**SSD 6011 - Mixed use residential development within the South West
Plot**

Submission by:

Mrs Anita Smythe

21 July 2013

Winter Solstice 9am

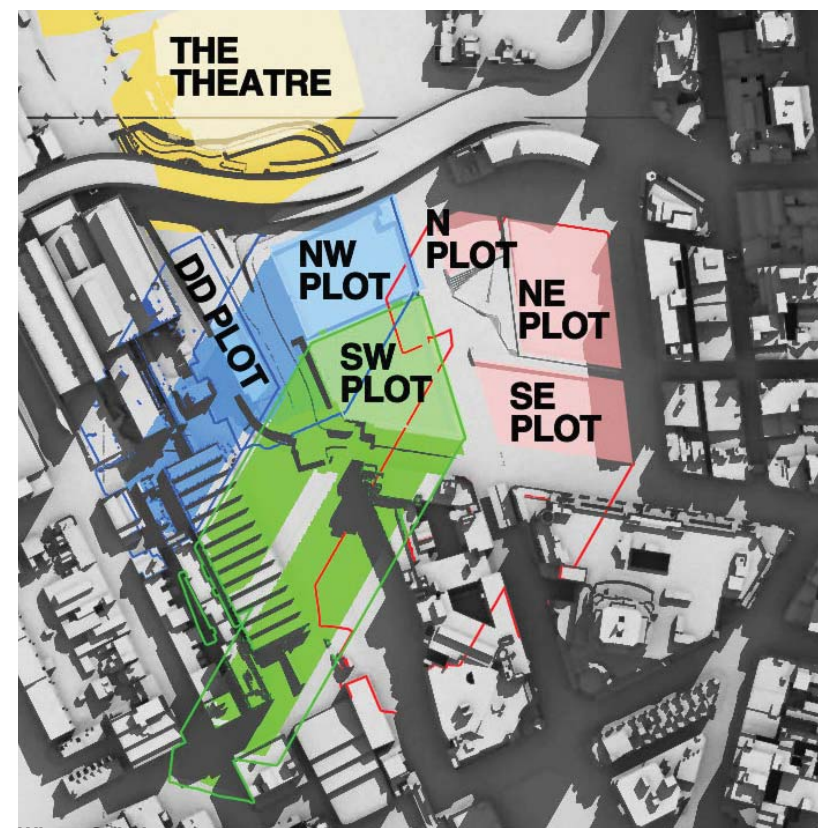
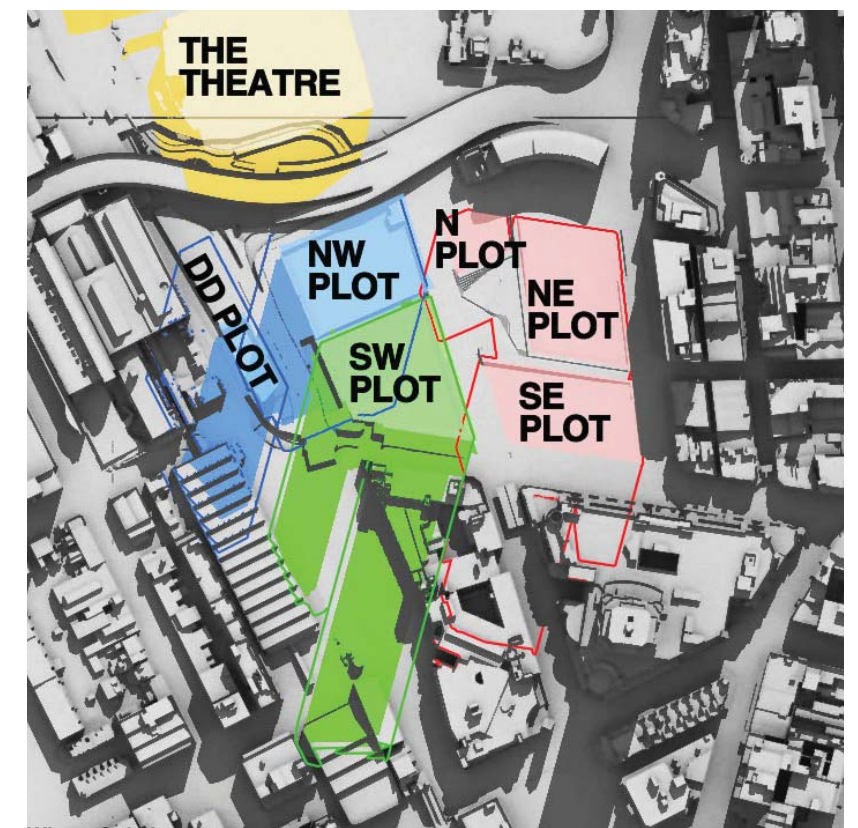
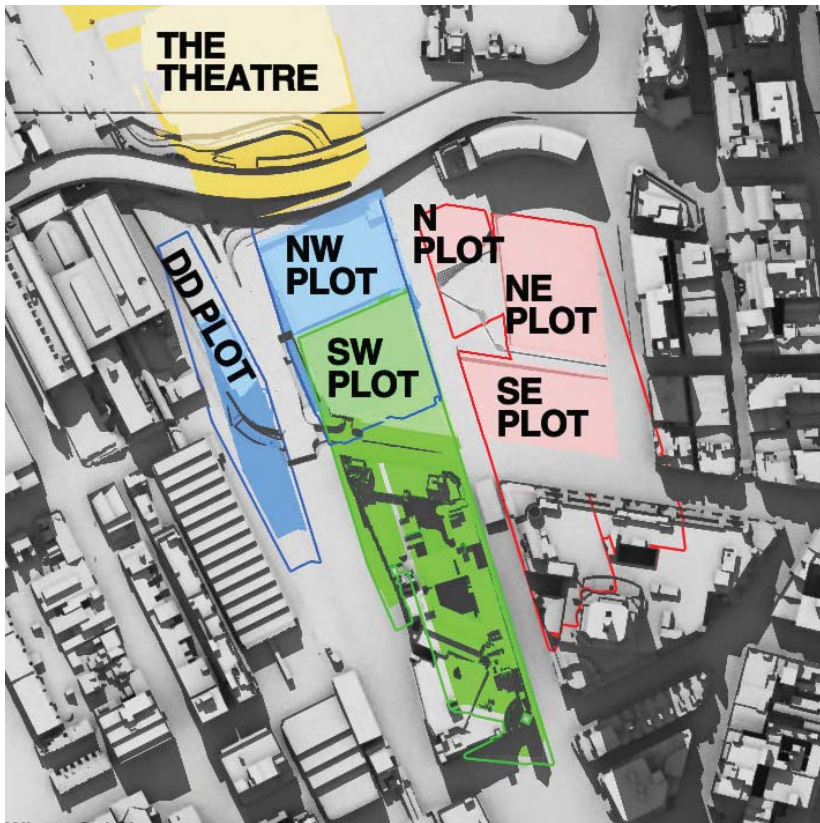
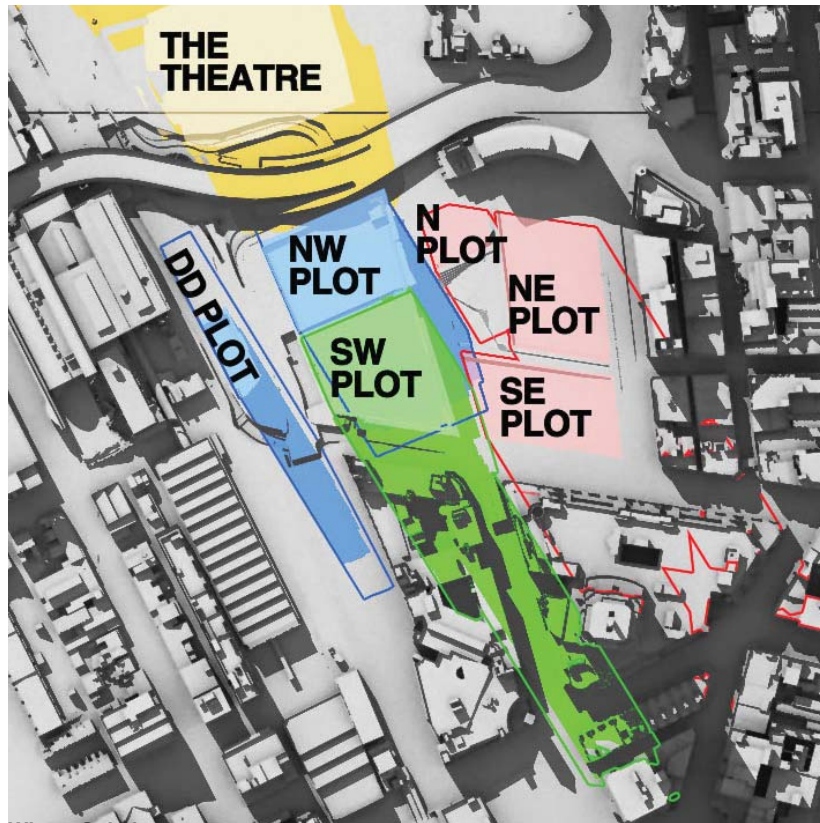
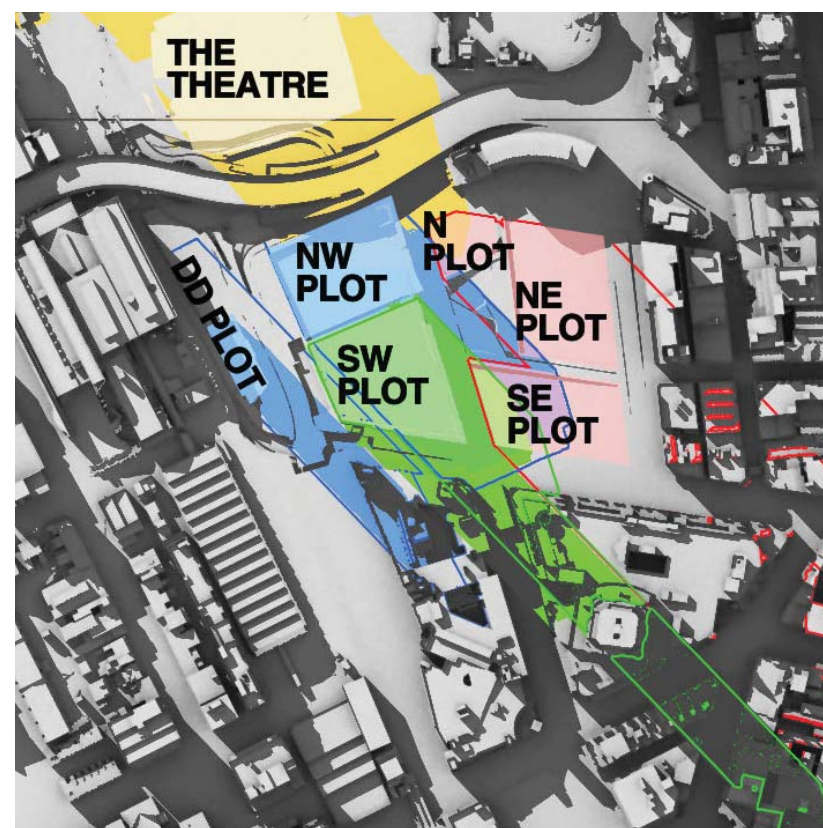
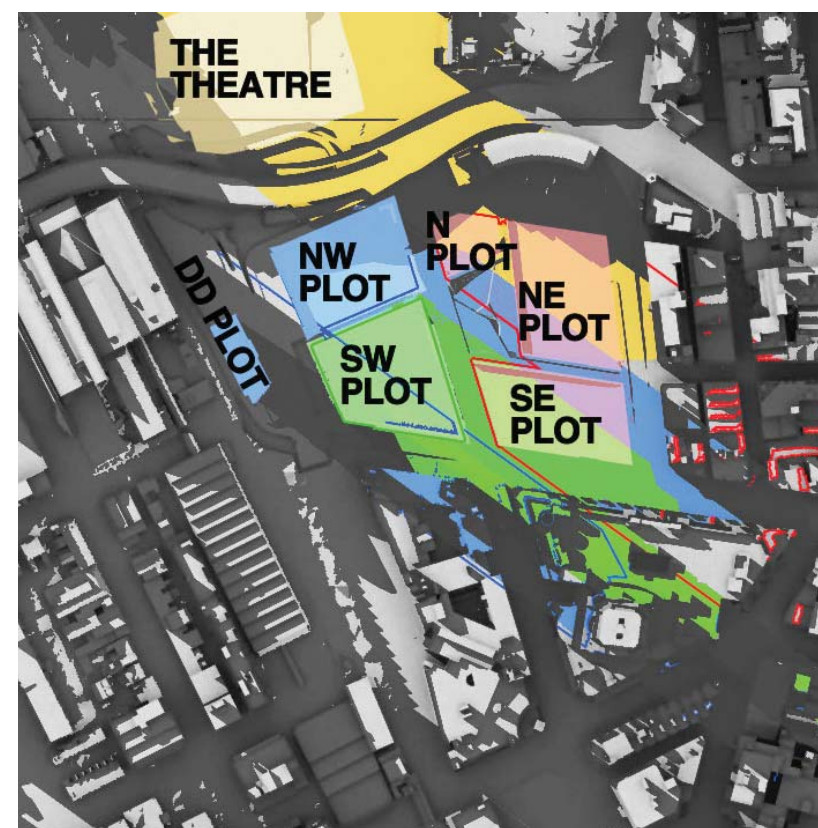
At 9am, 10am and 11am the west façade is totally in shadow due to other parts of The Peak building itself.

At 12pm there is still substantial existing shadowing on the west façade caused by the irregular shape of the west facade.

At 1pm the existing shadowing has been substantially removed, but not totally removed.

It can be concluded that some single aspect apartments on the west façade and some south-west dual aspect corner apartments currently receive less than 2 hours direct sunlight to habitable rooms and 50% of the private open space between 9am and 3pm on 21 June.

By 2pm the existing shadowing has been totally removed, but that is too late to achieve two hours of direct sunlight before 3pm.

At 9am, 10am and 11am the west façade is totally in shadow due to other parts of The Peak building itself.

At 12pm there is still substantial existing shadowing on the west façade caused by the irregular shape of the west facade.

At 1pm the existing shadowing has been substantially, although not entirely, removed. However, overshadowing of lower levels of the west façade by the concept proposal parameter plan shadows for the N,NE and SE plots has already started.

By 2pm the existing shadowing has been totally removed. However, overshadowing of the west façade by the SSDA4 and SSDA5 buildings has appeared and risen further up the west façade than the concept proposal parameter plan shadows for the N,NE and SE plots, which is still present.

At 3pm, the proponent states correctly that 45-45% of the western façade is overshadowed by the SSDA4 and SSDA5 buildings.

It can be concluded that, as a result of combination of the proposed development with existing shadowing of the west façade, some single aspect apartments on the west façade and the south-west dual aspect corner apartments which currently receive less than 2 hours direct sunlight to habitable rooms and 50% of the private open space between 9am and 3pm on 21 June will suffer additional overshadowing. It is beyond our skills to count the number of such apartments. We note that the proponent has made no attempt to do so.
